Marine Licensing  
Lancaster House  
Newcastle Business Park  
Newcastle upon Tyne  
NE4 7YH

**Your Reference:** TR030003  
**Our Planning Inspectorate  
Reference:** 20010091  
**Our Internal Reference:**  
DCO/2017/00001

30 April 2018

**RE: TILBURY2 – SECTION 89 AND THE INFRASTRUCTURE PLANNING  
(EXAMINATION PROCEDURE) RULES 2010: EXAMINING AUTHORITY’S “RULE 8  
LETTER”**

REVISED LIMITS OF DREDGING PLAN
TILBURY 2 DOCUMENT REF: POTLL/T2/EX/45

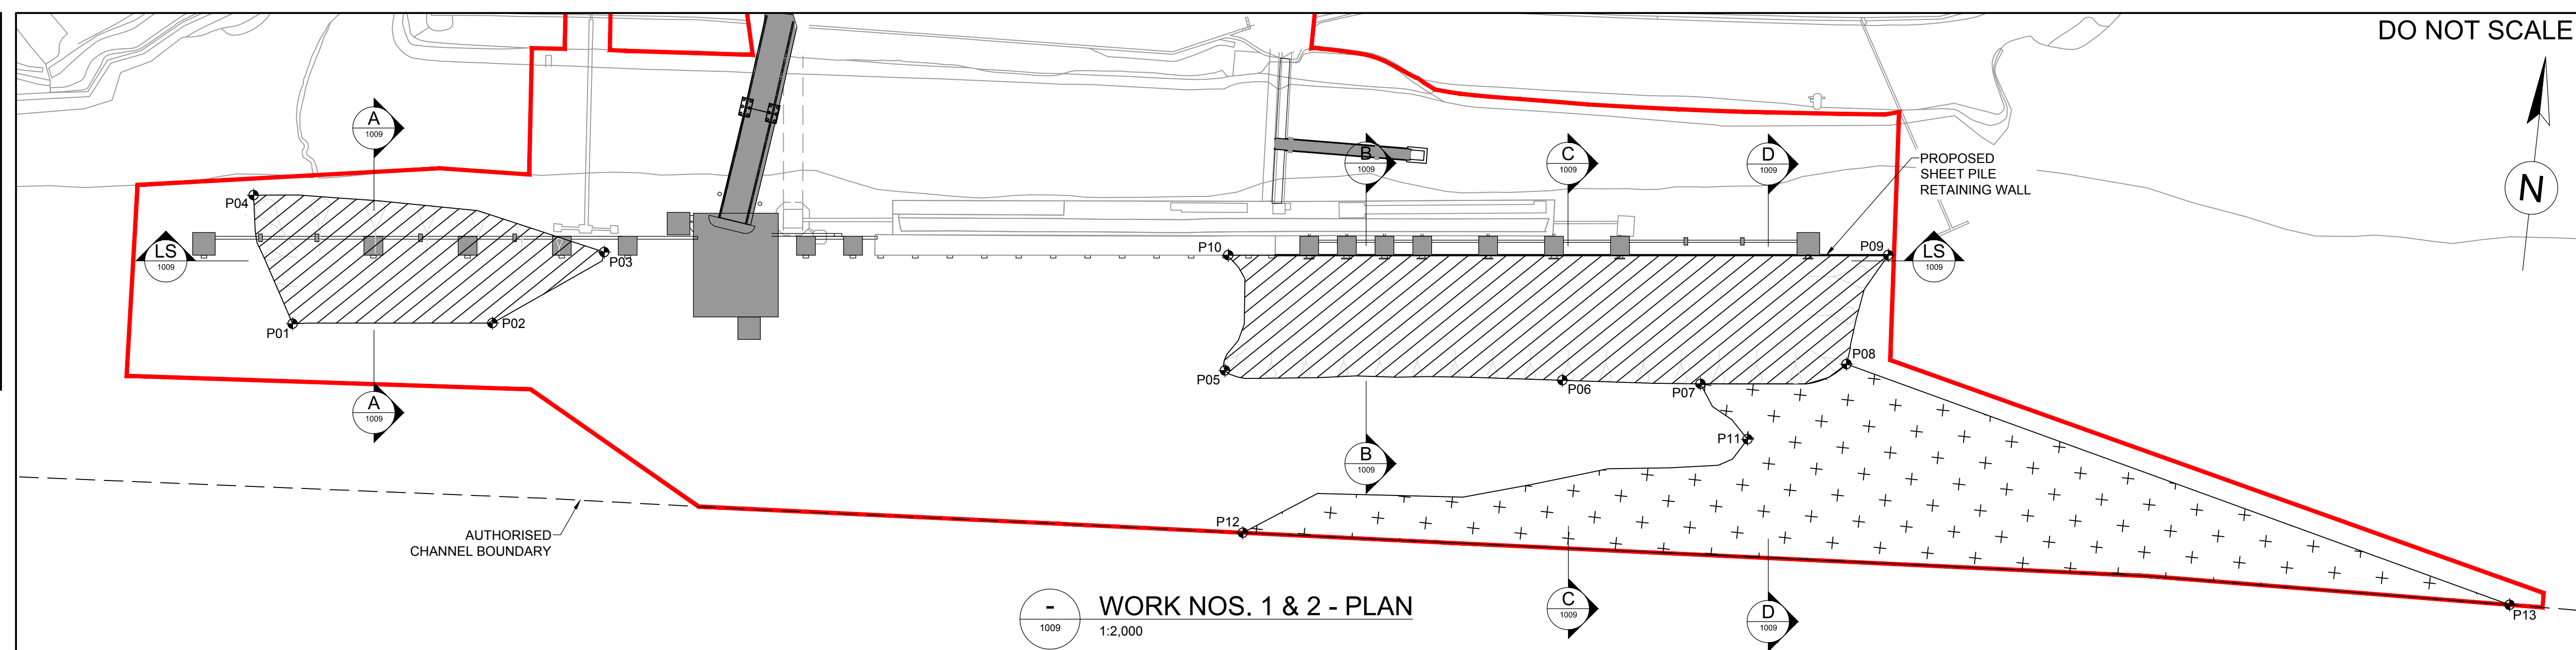
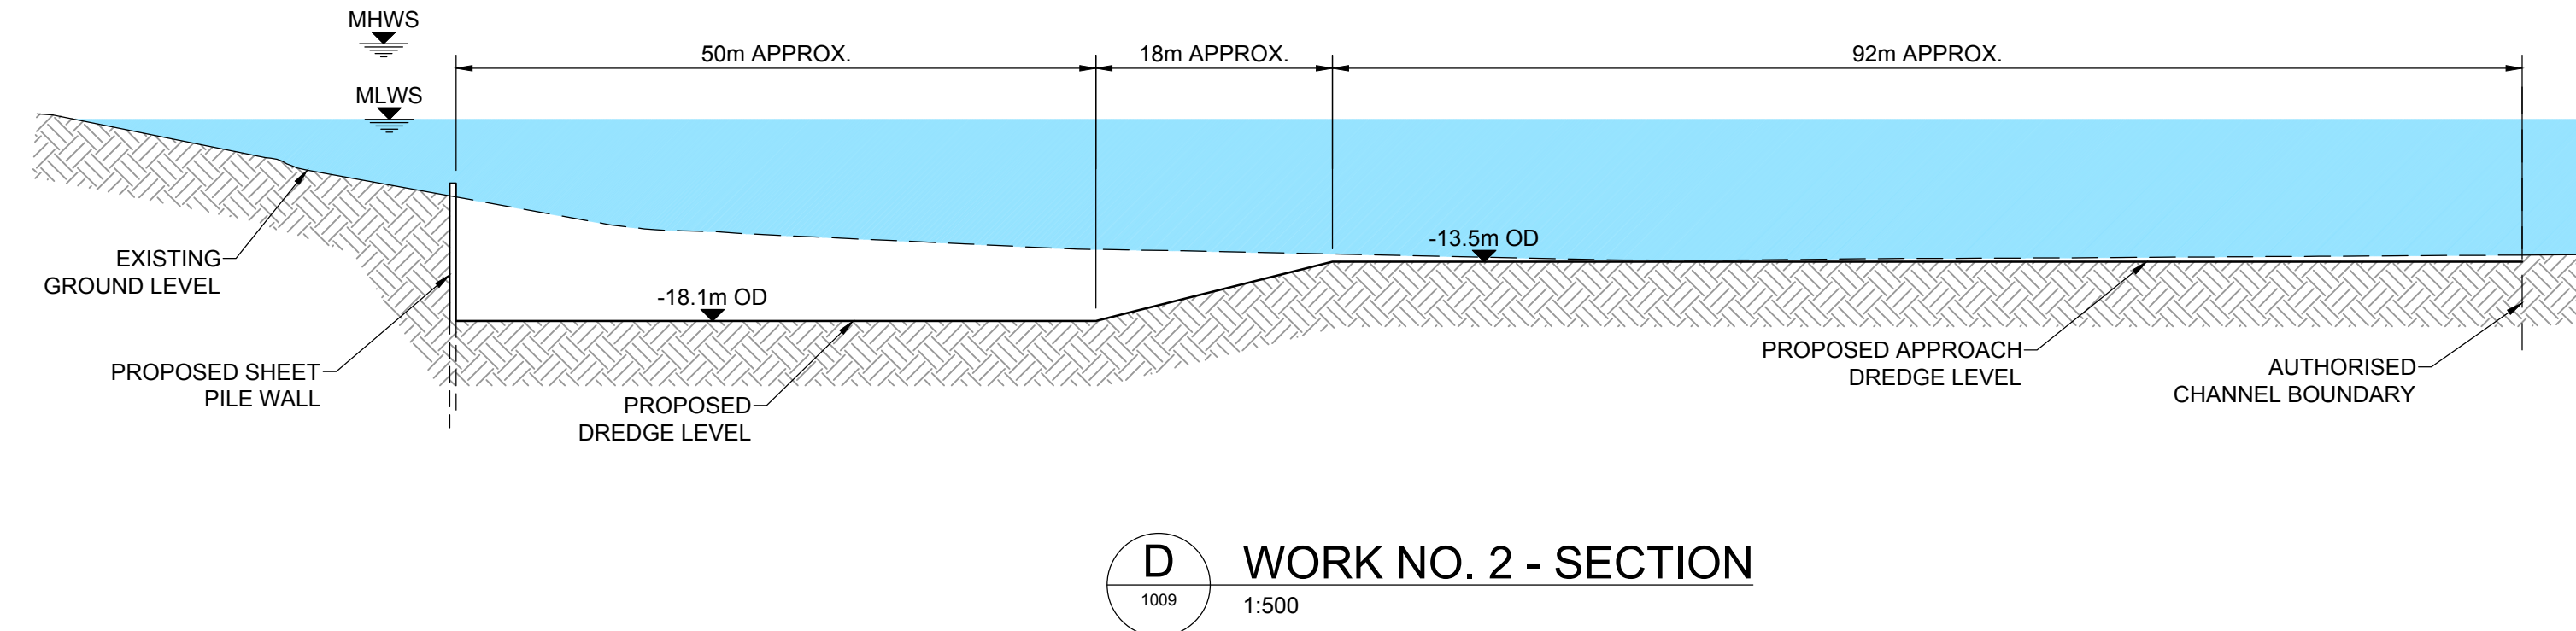
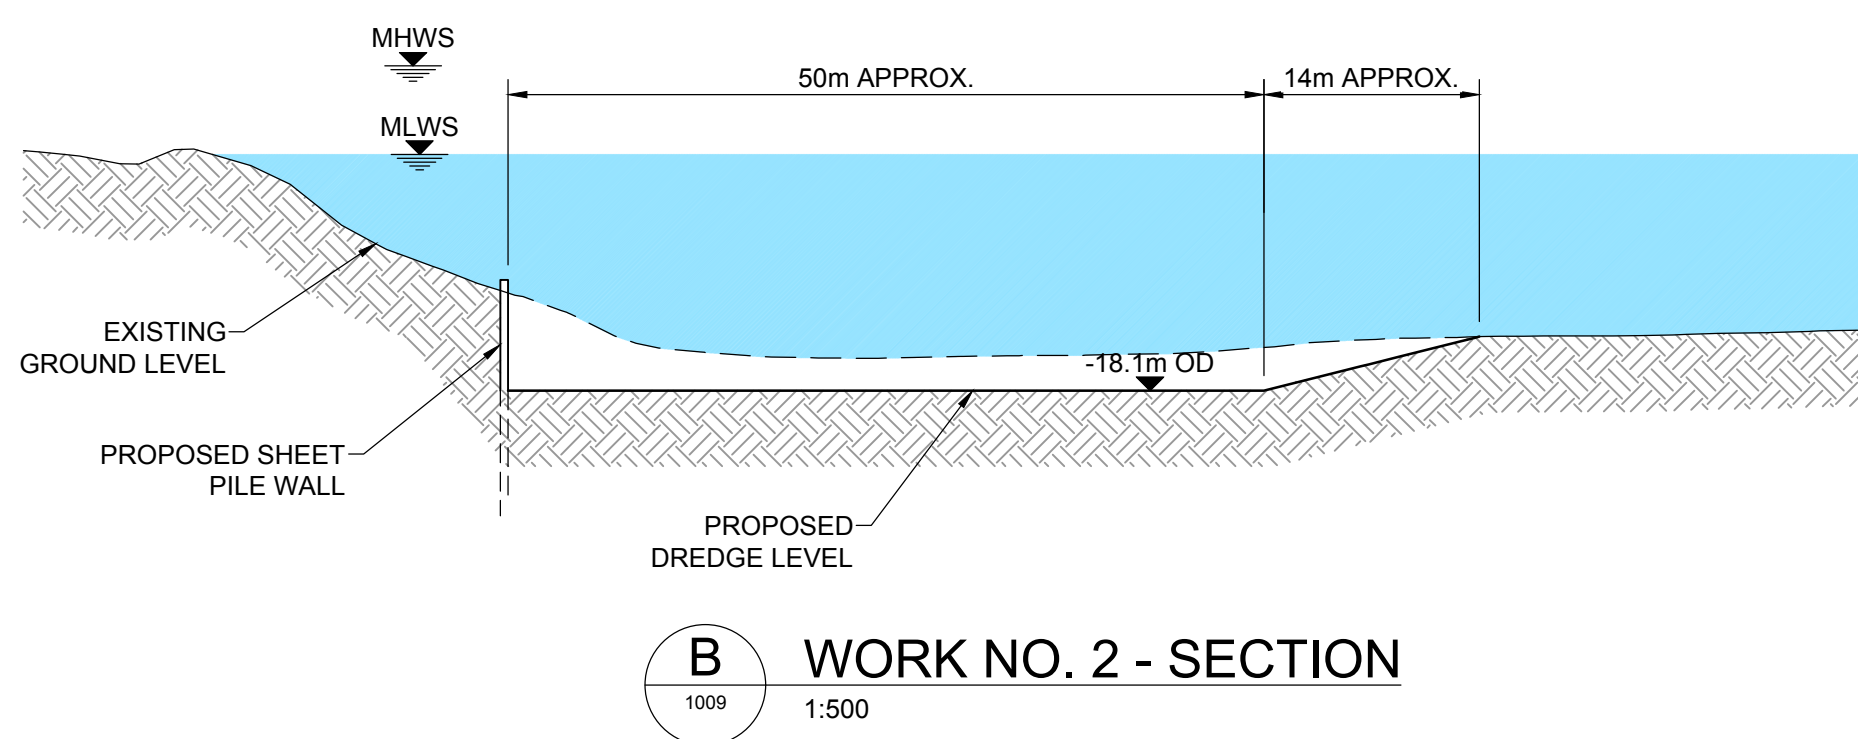
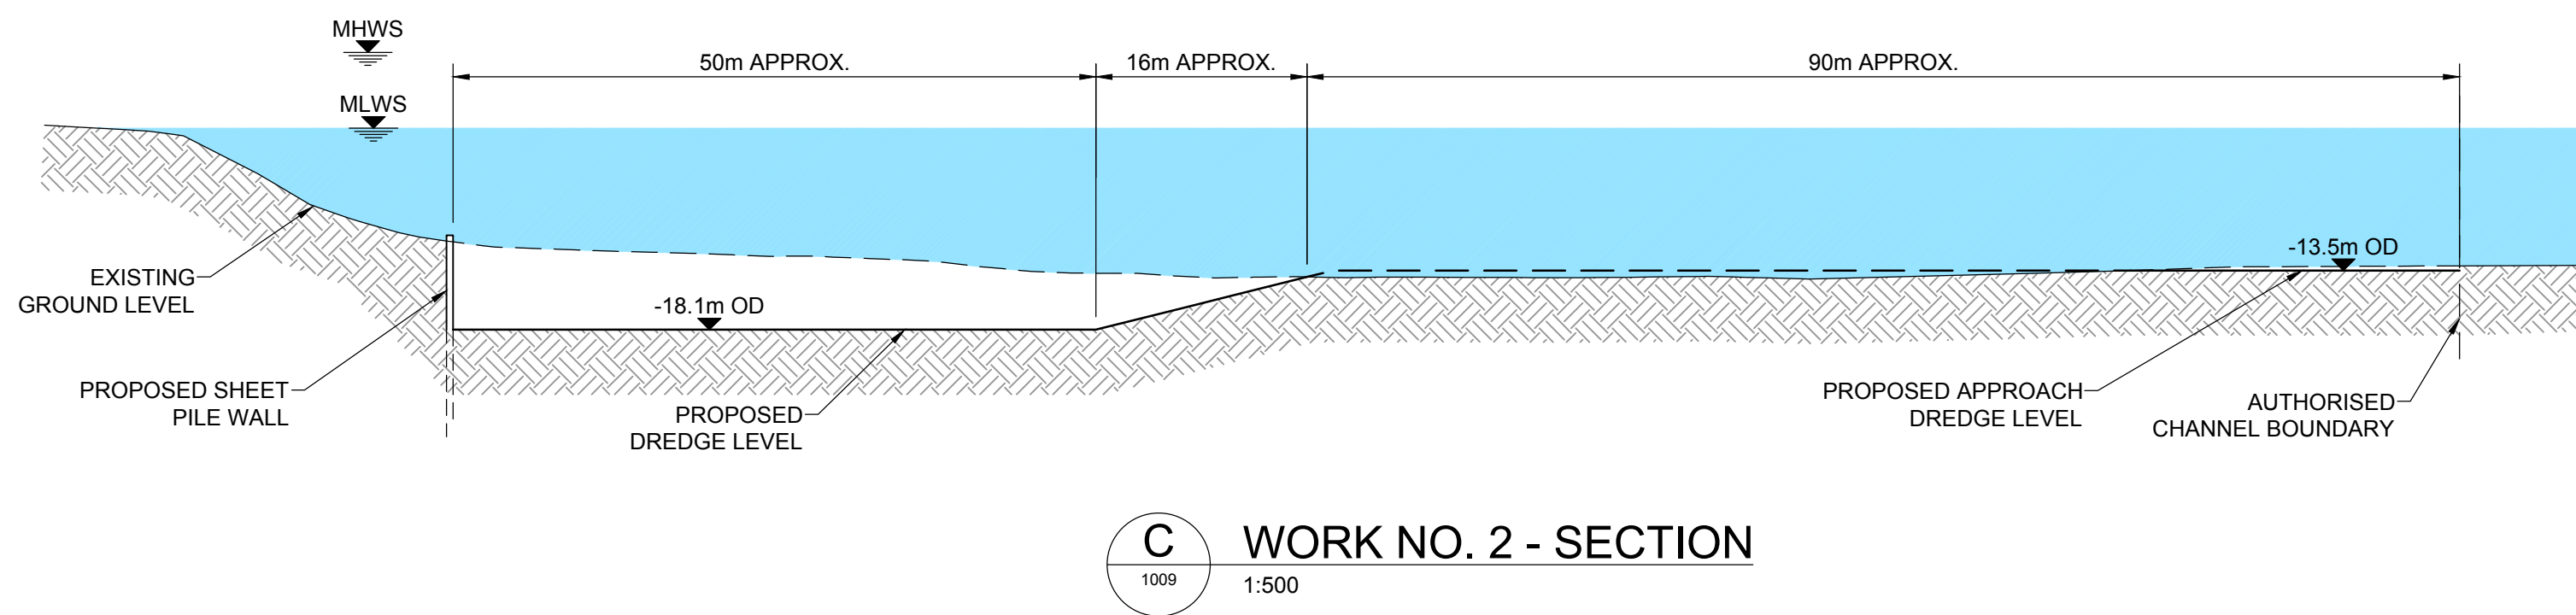
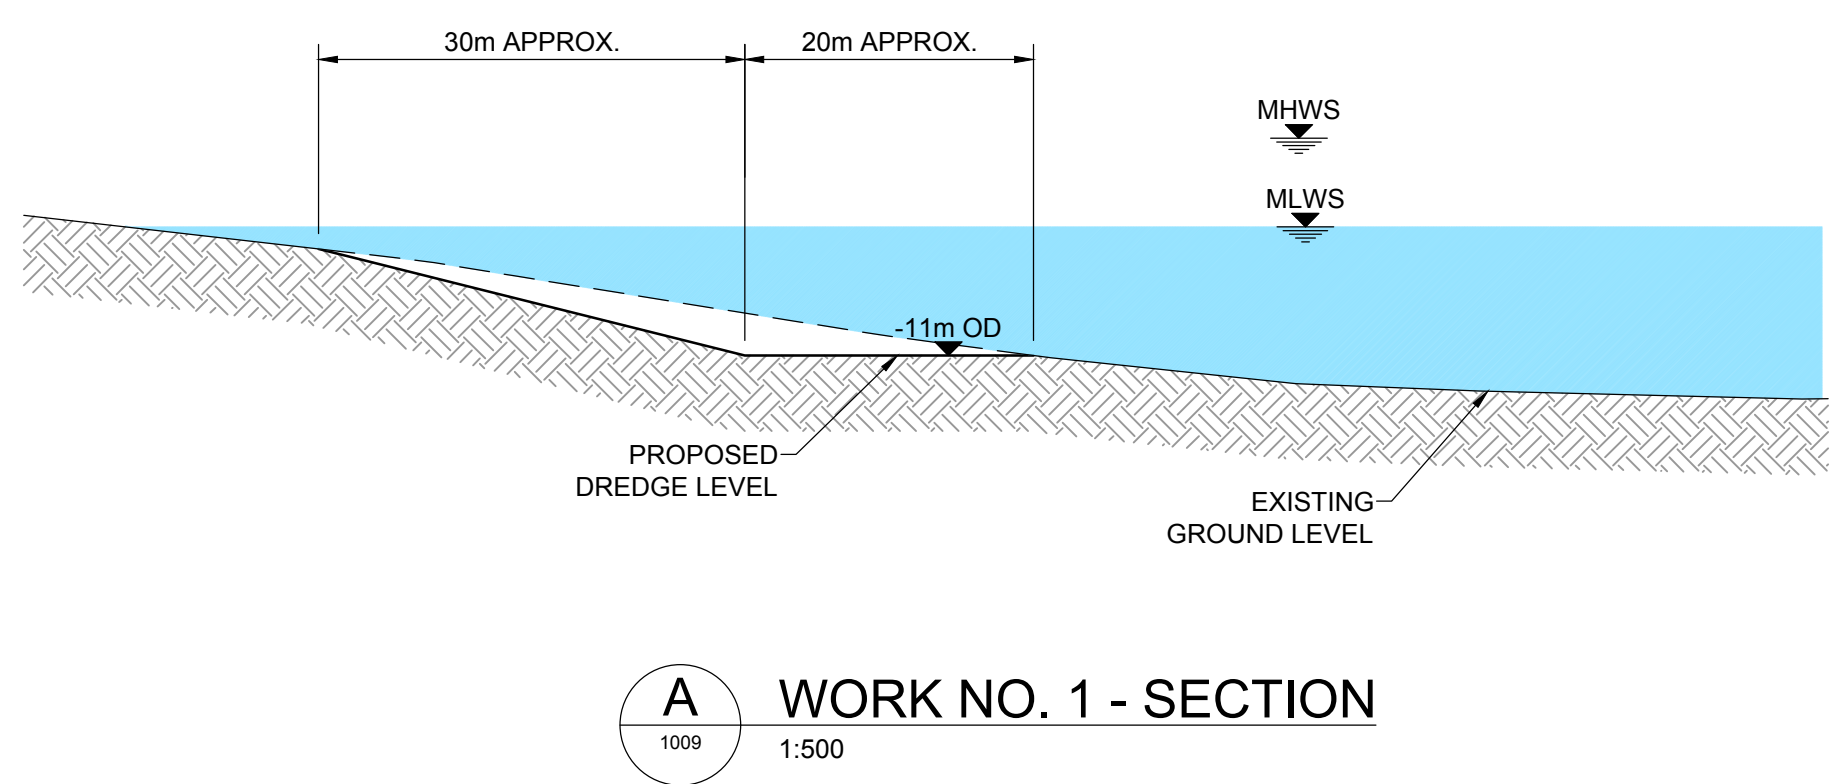
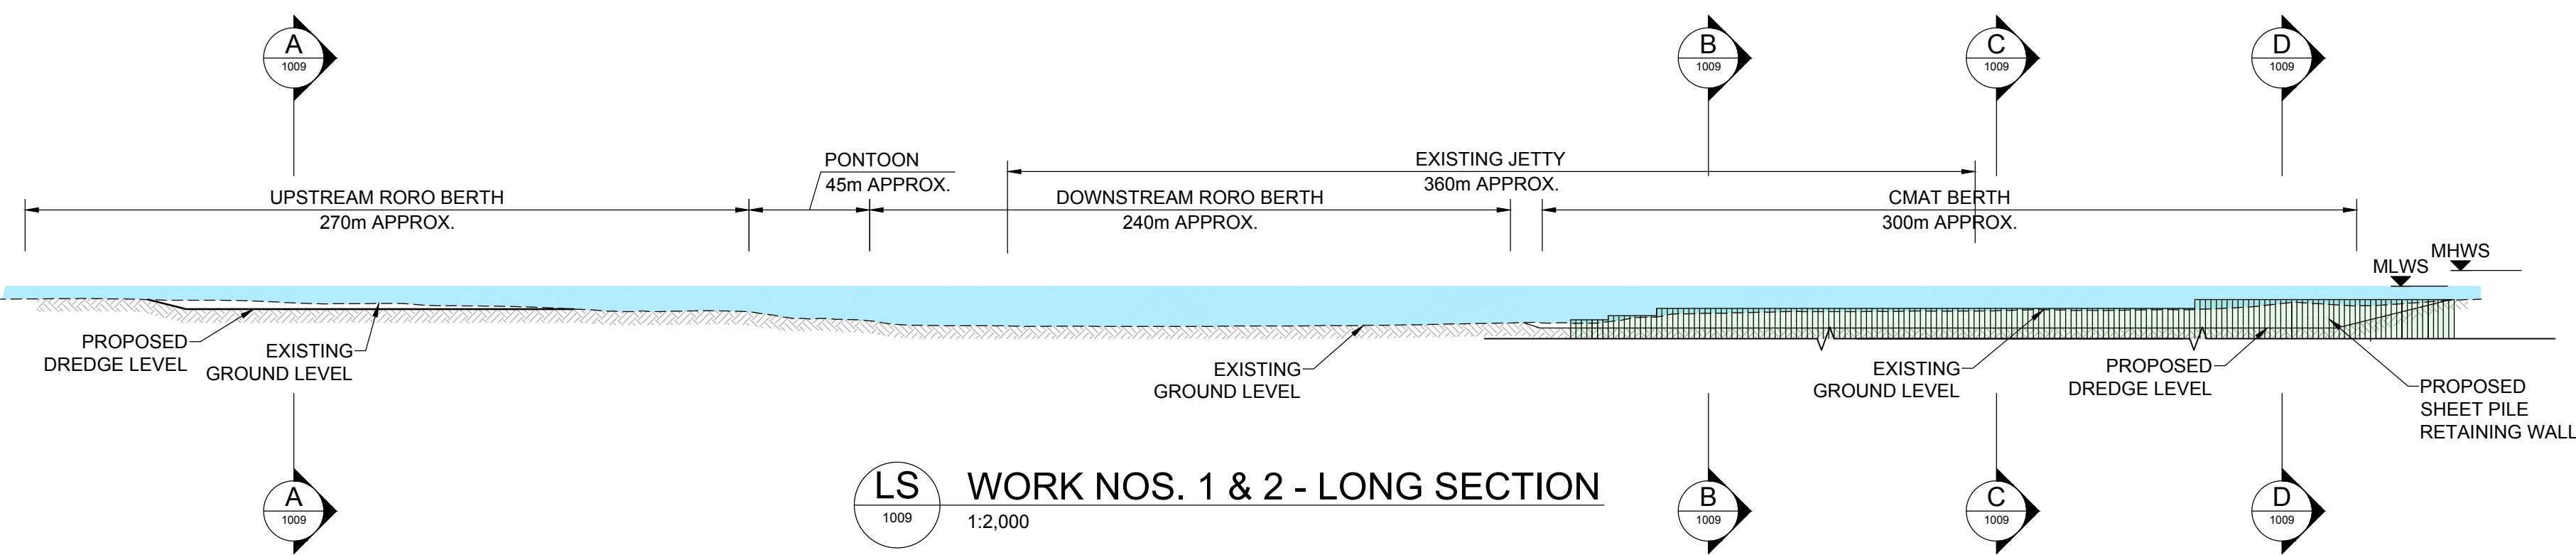
1.2.13 With regards to the Limits of Dredging Plan, as detailed by the PLA in the issue specific hearing on the 18<sup>th</sup> April 2018, the MMO would agree with the PLA that definitive limits are required and not approximate or illustrative ones.

3.3.1. The plan submitted at deadline 1 shows the areas of proposed dredging within the red line boundary, however there appears to be inconsistencies between the above works diagram and the cross sections. In the above works plan at C, a non-dredge gap is shown between the berth and approach channel dredge areas however this gap does not appear to be present on the cross section of C. Can the Applicant clarify this?

3.3.2. The MMO would also recommend that, as stated by the PLA, that definite limits are shown rather than proposed or illustrative ones.
